Application for a Non-Material Amendment Following a Grant of Planning Permission

ERECTION OF SINGLE STOREY REAR EXTENSION, REAR DORMER, FIRST FLOOR BALCONY ON FRONT ELEVATION ENCLOSED WITH FEATURE GABLE WINDOWS.

2 Hollybank Avenue WF17 0AQ - Planning Amend

Proposed Second Floor
1 : 100

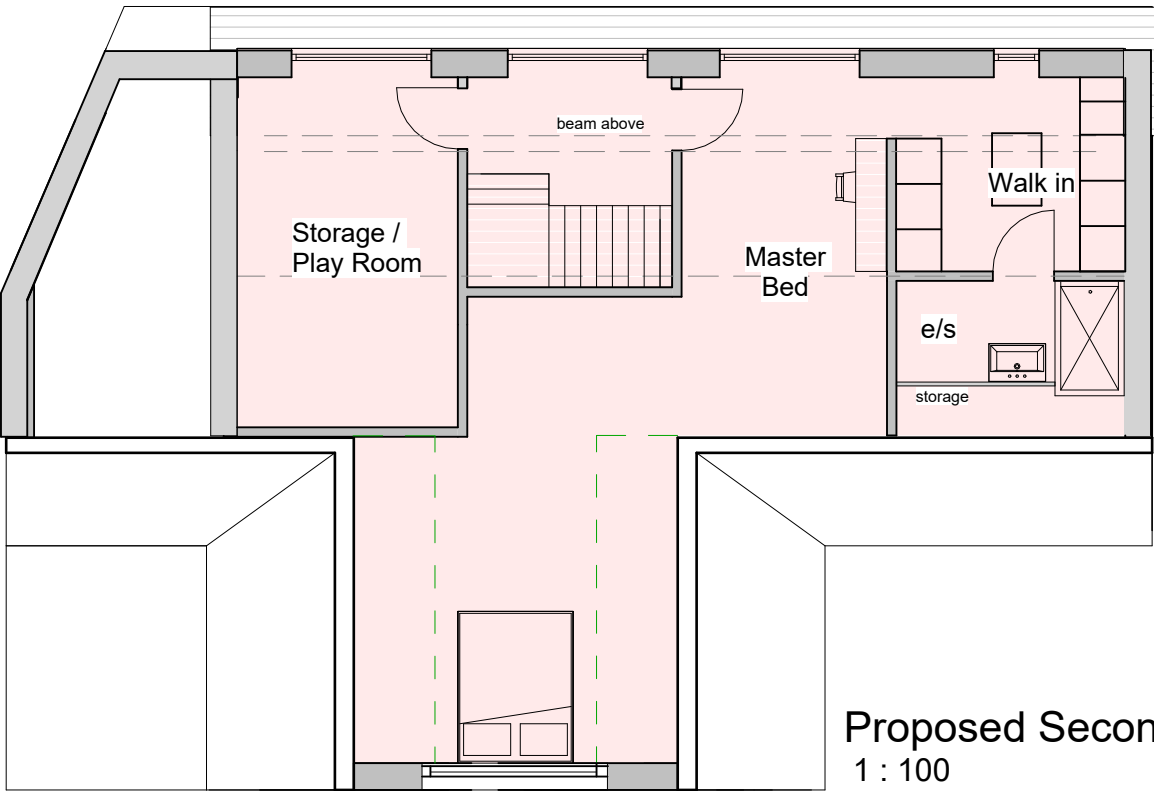
For a more uniformed look of the front elevation and to add an additional window to the front gable for safeguarding at night from the master bedroom.

Proposed Front Elevation
1 : 100

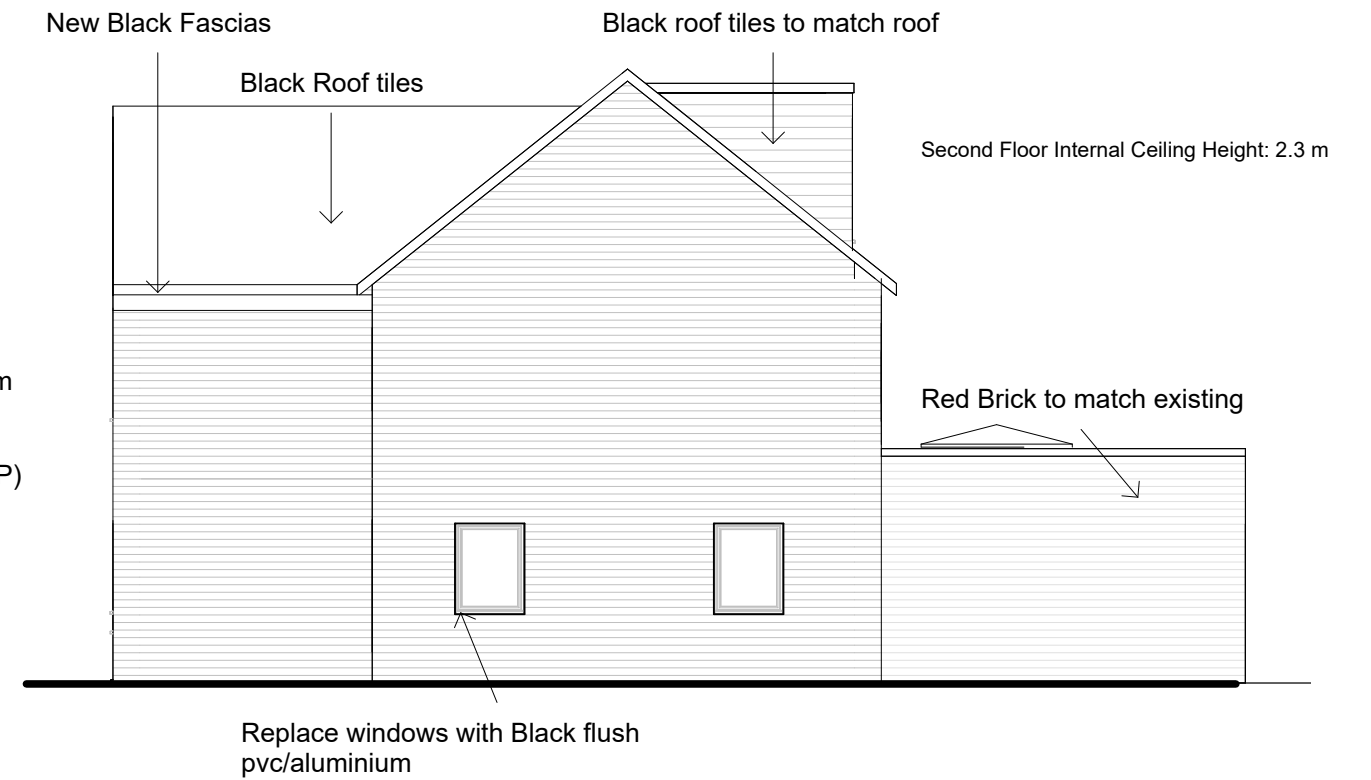
Change the window arrangement of the entrance gable and combine the 2 front gables to form a single gable.
